1st REVIEW – DEVELOPMENT PLAN – APPROVED WITH COMMENTS – (CH2018-7-DP-1)
CIMARRON HILLS FIRE PROTECTION DISTRICT

RE: File Number: PPR-1840

The Cimarron Hills Fire Department submitted site development PLOT PLANS to PEAK Consulting Services, Inc. for a fire code compliance review of a proposed site development for the **FREEDOM SPRINGS** consisting of a new RESIDENTIAL OCCUPANCY building at 734 Western Dr. The project includes the proposed construction located within the Cimarron Hills Fire Protection District.

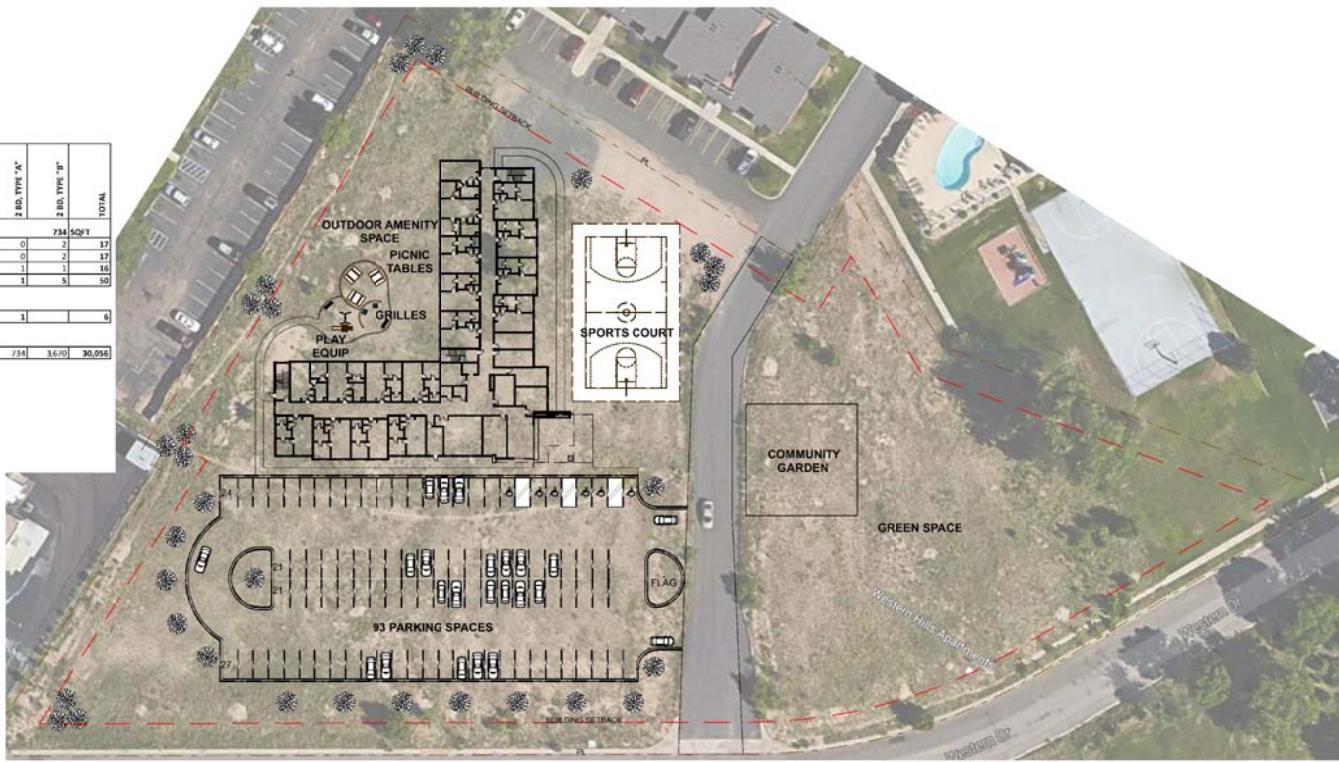
- 1) FIRE DEPARTMENT ACCESS** – Be advised that the fire code requires that all portions of the exterior of the building be accessible by fire hose line within 150-feet of where a fire truck can park. Be advised that any gate that compromises access to all exterior sides of the building will need to be equipped with a means for fire service access.
